## Response to Request for Information | SSD-87245208

This letter is prepared on behalf of 17 Oxford St Pty Ltd (the Applicant) in respect of SSD-87245208, a State Significant Development Application for a mixed-use development incorporating in-fill affordable housing at 13-15 and 17 Oxford Street and 2 Verona Street, Paddington.

Drawing Title  
**LEVEL 1 FLOOR PLAN**

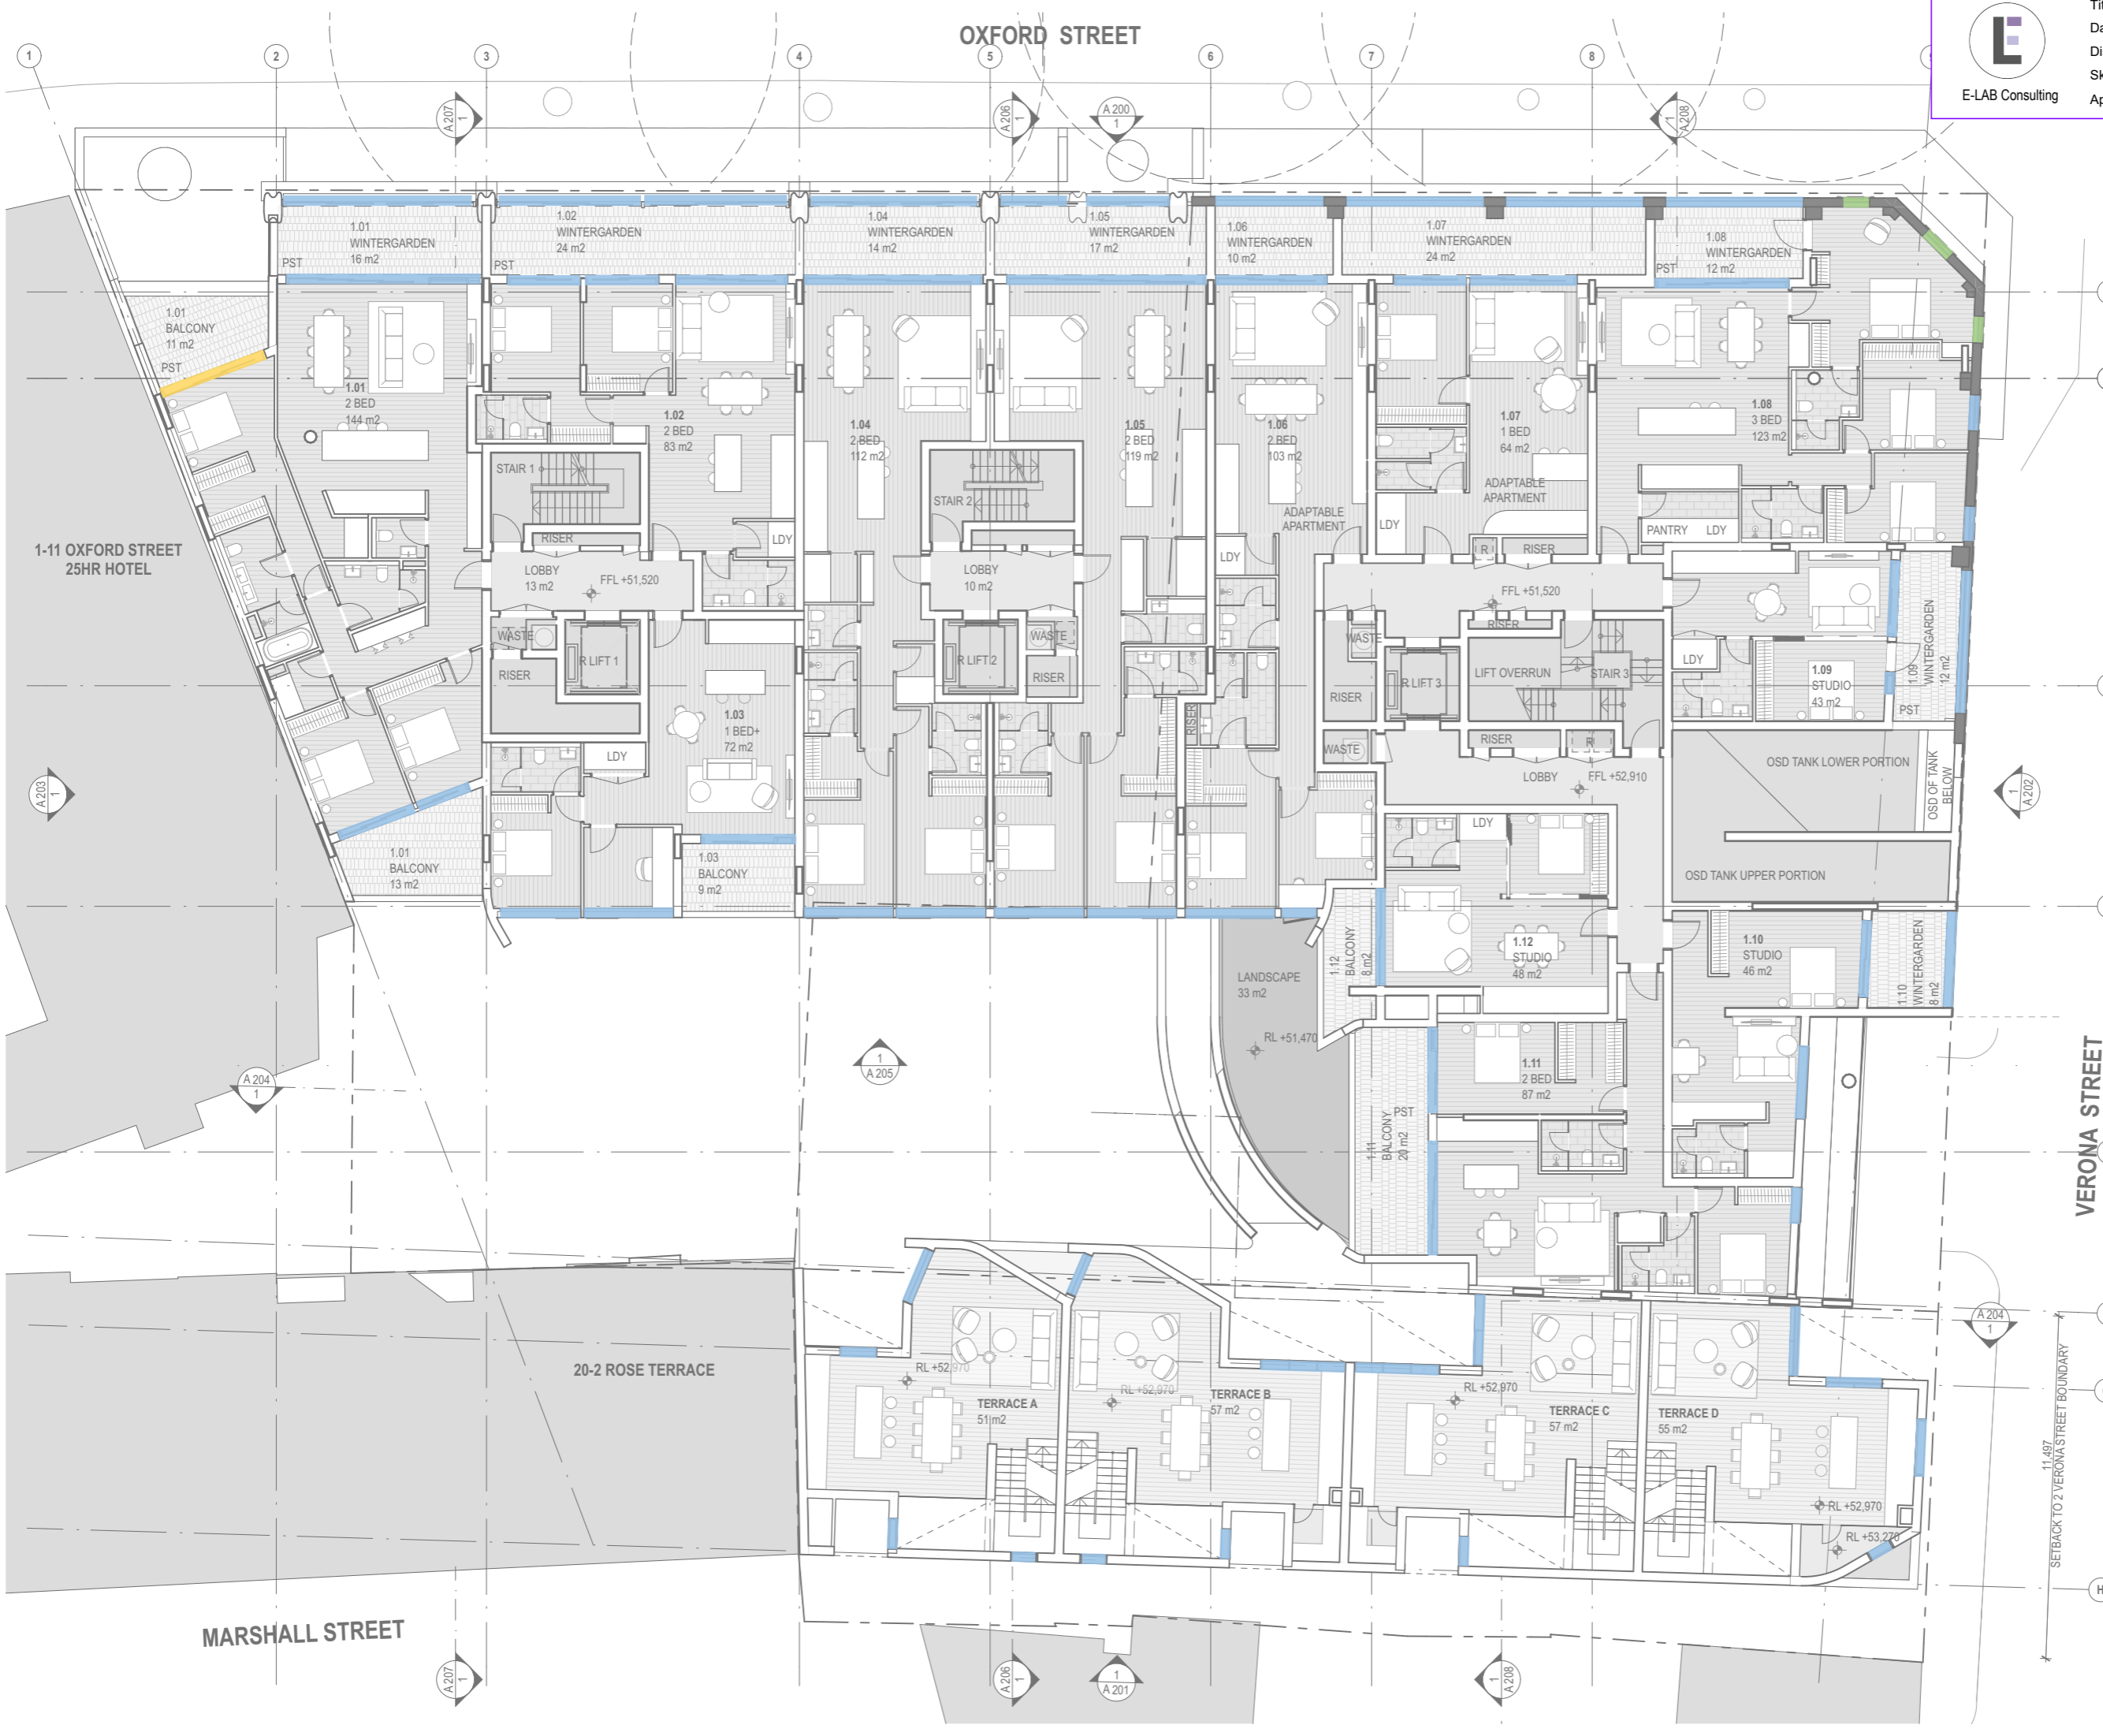
RFI	Applicant Response
<b>NSW Department of Planning, Housing and Infrastructure</b>	
<p>1. Architectural plans demonstrate that the wintergarden for Apartment 1.13 (studio) is impeded by a nib wall. Clarify whether this is a drawing error. If not, provide an assessment to demonstrate that the nib wall would not adversely affect the internal and external amenity of the unit.</p>	<p>TZG confirm that the nib wall shown within the wintergarden of Apartment 1.13 is not a drafting error.</p> <p>The nib wall forms part of a larger structural concrete wall system required to eliminate transfer beams above the loading dock at the ground floor level. This structural arrangement has been necessitated by the City of Sydney's requirements to provide a loading dock capable of accommodating their 10.6 metre long HRV Council waste collection vehicle. The wall configuration is therefore a non-negotiable structural response to Council's operational requirements.</p> <p>Notwithstanding the presence of the nib wall, we confirm that the amenity of Apartment 1.13 is not adversely affected, for the following reasons:</p> <ul style="list-style-type: none"> <li>• <b>Minimum Balcony Compliance:</b> The larger portion of the wintergarden, as delineated by the blade wall, remains compliant with the minimum balcony area requirements for a studio, achieving 6sqm. The functional outdoor amenity of the apartment is therefore maintained in full.</li> <li>• <b>Residual Space:</b> The remaining area of the wintergarden created on the other side of the nib wall, while not forming part of the primary balcony area, is not rendered unusable. This space presents an opportunity for a garden or built-in joinery, which would contribute positively to the overall amenity and liveability of the apartment. We believe it is better to provide this space to the tenant rather than not.</li> <li>• <b>No Reduction in Internal Amenity:</b> The nib wall has no negative impact on the internal layout, or floor area of the apartment itself.</li> </ul> <p>In summary, the nib wall is a required structural element driven by a Council's loading dock requirement, and its presence does not result in any reduction to the internal or external amenity of Apartment 1.13.</p>

<p>3. The Department remains concerned that the amenity of affordable housing is disproportionate to market units. Affordable units are generally subject to lower cross ventilation (approximately 42% cross ventilated) and many have constrained solar access to living room windows via wintergardens, while also being more noise affected. You must further explore and demonstrate opportunities to ensure</p>	<p>A review of the Level 1 affordable housing floor plate has been undertaken, resulting in a series of design amendments that substantially improve the amenity of the affordable apartments and bring the Level 1 floor plate into closer alignment with the build to sell product on the levels above.</p> <p><i>Statutory Context:</i> There is no statutory requirement that the amenity of affordable housing within a mixed development be equivalent to that of market apartments. Notwithstanding this, the amended design delivers a standard of amenity that is generous in absolute terms. The affordable apartments feature floor to ceiling glazing, oversized private open spaces in many instances, apartment sizes that</p>

4. Amend the proposal to ensure that wintergardens are only provided where required for noise affected apartments.

<p><i>Affordable Housing</i></p> <p>12. The City reiterates concern that the affordable housing apartments would have the poorest amenity of the proposed development. Most of these apartments continue to be noise-affected, without access to open balconies and 60% of the proposed affordable apartments are still not naturally cross ventilated in accordance with the ADG. The solar access diagrams demonstrate that the affordable housing apartments on level 1 receive solar access to the wintergarden</p>	<p>Refer to RFI #3 above.</p>

Furthermore, it is unclear why apartments 1.13 and 1.12 have wintergardens when the market apartments above all have open balconies. The noise report confirms these apartments are not noise affected, so the City is of the view that these private open spaces should not be enclosed and should be excluded from the Affordable Housing gross floor area calculation.

*Changes to Level 1:* The Level 1 floor plate has been redesigned to replicate the Level 2 floor plate as closely as possible, reflecting an equivalent standard of amenity to the build to sell product immediately above. Courtyard facing balconies to dual aspect apartments have been absorbed into the apartment interiors, increasing effective internal floor area. Apartments 1.01 and 1.02 have been consolidated into a single larger dual aspect, naturally cross ventilated apartment (now numbered 1.01), replicating the floor plan of the market apartments on the levels above. As a result of these amendments, the cross ventilation and solar access performance of the Level 1 floor plate is only marginally different from Level 2.

*Wintergardens and Open Balconies:* Wintergardens are retained for apartments 1.01, 1.02, 1.04 and 1.05, which front Oxford Street and are noise affected. Wintergardens are also retained for apartments located behind the existing Verona Street facade, where the heritage fabric is to be preserved, and for the studio apartment above the loading dock, where the wintergarden provides additional separation from the loading dock below. Courtyard facing apartments that are not noise affected are provided with open balconies consistent with the market apartments on the levels above.

Wintergardens are retained where required by noise affectation. Apartments 1.01, 1.02, 1.04 and 1.05 front Oxford Street and are noise affected; wintergardens are therefore retained for these apartments. Wintergardens are also retained where private open space sits within the existing Verona Street building facade, in order to preserve the existing building fabric and character, this applies to

RFI	Applicant Response
	apartments 1.06, 1.07 and 1.08. Wintergardens are also provided to apartments 1.09 and 1.10 due to their adjacency to Verona Street and the building's loading dock. Courtyard-facing apartments 1.03, 1.11 and 1.12 are provided with open balconies, as they are not noise affected.

PROPOSED GROUND FLOOR PLAN SHOWING SURVEY LEVELS

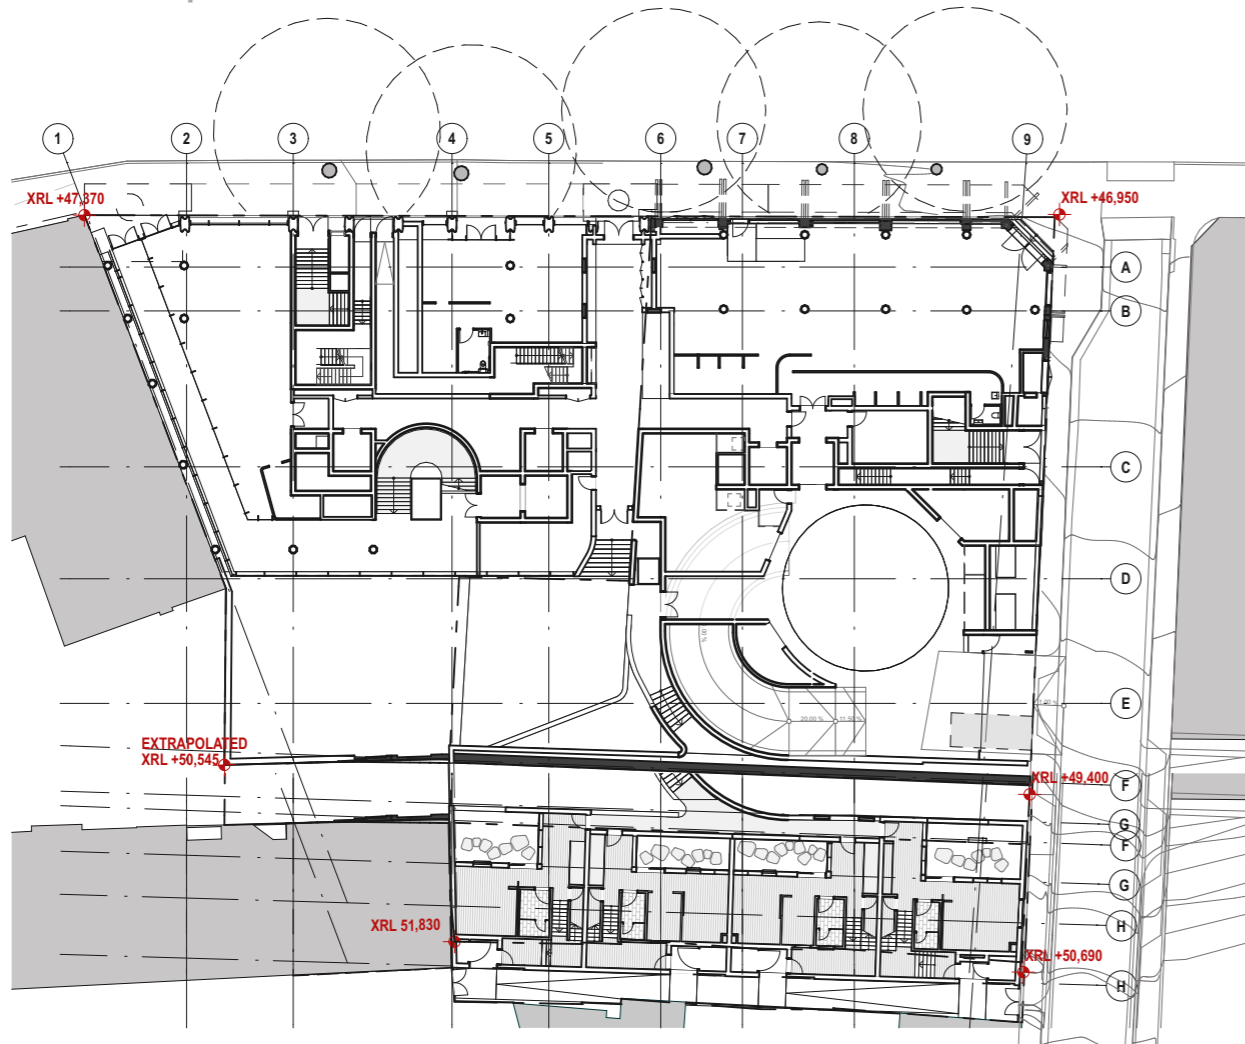
RFI	Applicant Response
<p>9. Provide survey levels of existing natural ground on plans.</p>	<p>Survey levels of existing natural ground have been provided on the ground floor plan within the amended architectural drawing package. Existing survey levels are denoted with an "X" prefix before the relative level notation, such as "XRL". Additional survey levels have been provided on the ground floor plan for clarity.</p> <p>Survey levels are those provided by Boxall Surveyors, as issued on 16 December 2025. Proposed levels are denoted on the plans as "RL" followed by the numeric value.</p>
<p><b>City of Sydney Council</b></p> <p><i>Clause 6.60D of the Sydney LEP</i></p> <p>10. The City reiterates that the 'alternative' height and floor space ratio incentives under clause 6.60D of the Sydney LEP only apply if the proposed building will deliver new cultural and creative uses and be used wholly for those identified non-residential uses listed in subclause 6.60D(4)(a) (i)-(vii).</p> <p>These controls incentivise strategic land use outcomes for Oxford Street and its potential as a 24-hour cultural and creative hub and Special Entertainment Precinct.</p> <p>An amendment to clause 6.60D of the Sydney LEP was made on 12 December 2025 to clarify the intention of this clause. The amendment makes clear that buildings which will only be used for non-residential uses the service the creative business precinct are able to access the uplift. While the City notes that savings provisions apply, the amendment simply clarifies the original intent of clause 6.60D and does not change its original intended purpose.</p>	<p>Legal advice has been obtained, including a supporting opinion from Senior Counsel, which has been provided to both DPPI and Council. This advice confirms that the project is eligible for the 'alternative' height and floor space ratio controls under Clause 6.60D of the Sydney LEP 2012.</p> <p>In addition, the project benefits from a savings provision introduced by Sydney Local Environmental Plan 2012 (Amendment No. 113), gazetted on 12 December 2025. Clause 1.8A(10) provides that a development application lodged, but not finally determined, prior to the commencement of the amendment is to be determined as if the amendment had not commenced.</p> <p>As the application was lodged on 26 November 2026 and remains undetermined, it is to be assessed under the planning controls in force at the time of lodgement. Accordingly, the amendments introduced by Amendment No. 113 do not apply to the determination of this application.</p>
